**KIRKLEES METROPOLITAN COUNCIL  
INVESTMENT & REGENERATION SERVICE**

**DELEGATED DECISION TO DETERMINE PLANNING APPLICATIONS**

Reference No:	<b>2023/62/90816/W</b>
Site Address:	2, Hollin Hall Lane, Scapegoat Hill, Huddersfield, HD7 4PF
Description:	Demolition of existing building and erection of dwelling with associated external works and erection of detached garage
Recommending Officer:	William Simcock

## **Officer Report – 2023/90816**

PROJECT TITLE <b>HOLLIN HALL LANE</b>			
DRAWING TITLE <b>BLOCK PLAN</b>			
SCALE <b>1:500</b>	DRAWN <b>EG</b>	CHECKED <b>JH</b>	PROJECT REFERENCE <b>ODS 22/519</b>
PAPER SIZE <b>A3</b>	DWG NUMBER <b>(20)003</b>	DATE <b>01/03/23</b>	REVISION <b>B</b>
CLIENT <b>MR &amp; MRS WOLSTENCROFT</b>

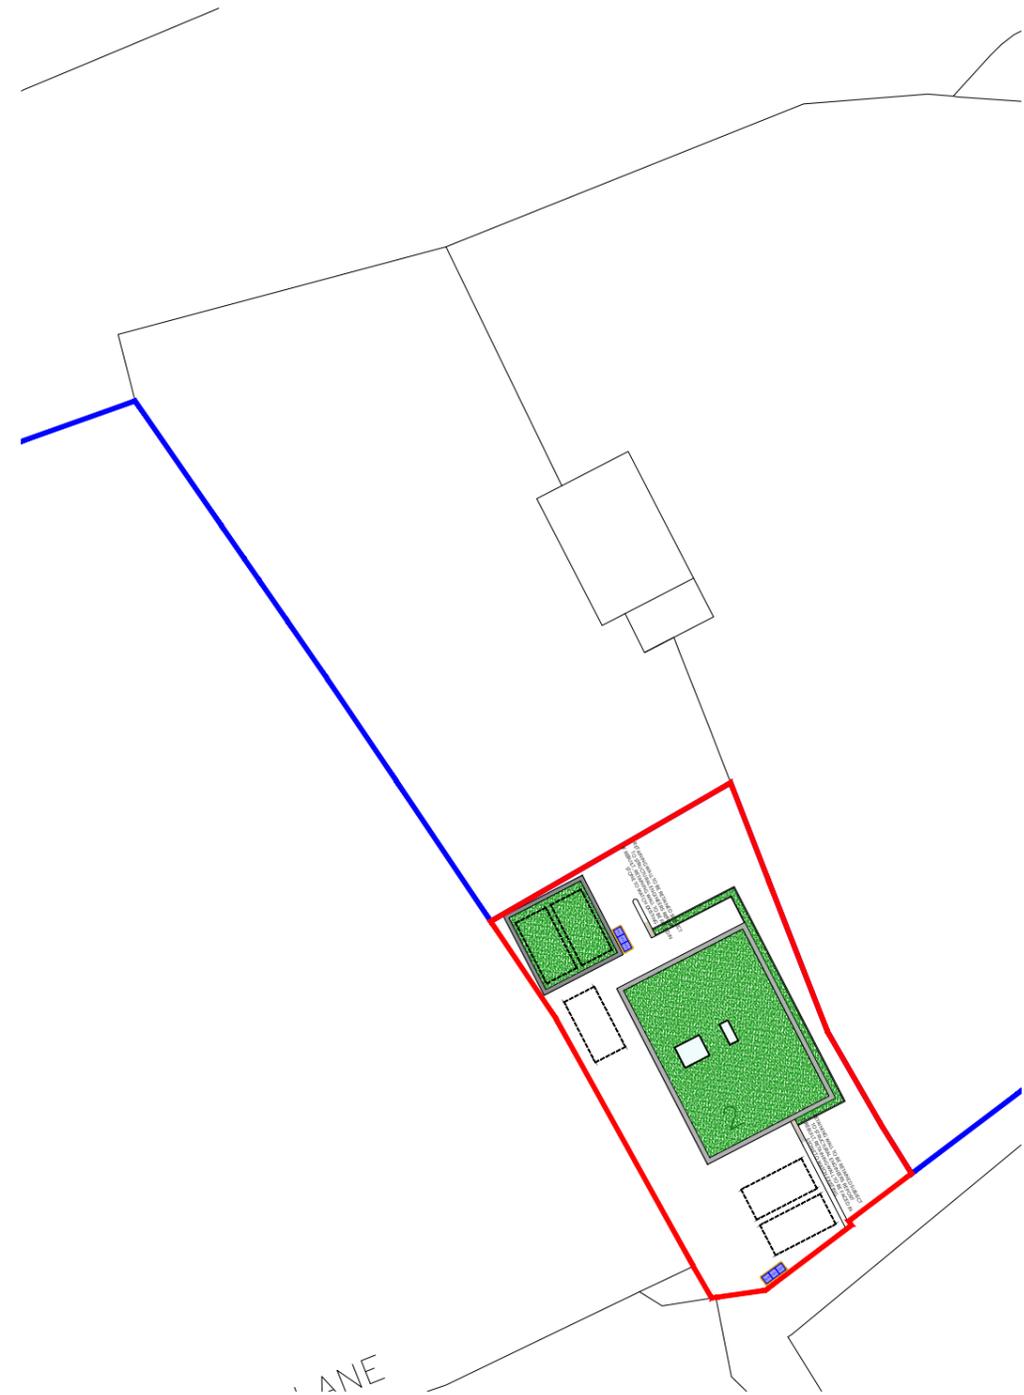
11-Jul-2023: Amended site plan to clarify extent of existing retaining walls and any works to them.

The eastern boundary of the site is formed by a stone retaining wall of viable height. There are further retaining walls within the site; one to the south of the dwelling, which continues the line of the eastern wall of the existing house, and one to the north, which the architect has explained is behind the metal outbuilding and therefore not clearly visible. An annotation on the latest version of the site plan explains that the retaining walls within the site are to be retained subject to a structural engineer's report, and that if rebuilding is necessary, they will be faced in natural stone. This can be conditioned.

Refuse collection arrangements are indicated in blue shading on the proposed site plan, with storage space at the side of the garage and a collection point to the side of the entrance. These would be convenient to use and would not be visually obtrusive.

5. Prior to the development being brought into use, the areas to be used for the parking and manoeuvring of vehicles as indicated on the block plan 20(003) Revision B shall be laid out with a hardened and drained surface. Any new or replacement hard surfacing shall be formed in accordance with the Communities and Local Government; and Environment Agency's 'Guidance on the permeable surfacing of front gardens (parking areas)' published 13th May 2009 (ISBN 9781409804864) as amended or superseded. These shall thereafter be retained and kept clear of all obstructions to their use for the parking of vehicles.

6. Prior to the development being brought into use, the areas indicated to be used for the storage and collection of wastes on the block plan 20(003) Revision B shall be provided and laid out with a hardened and drained surface, and shall thereafter be retained as such, free from obstructions to their use for the storage and collection of wastes.
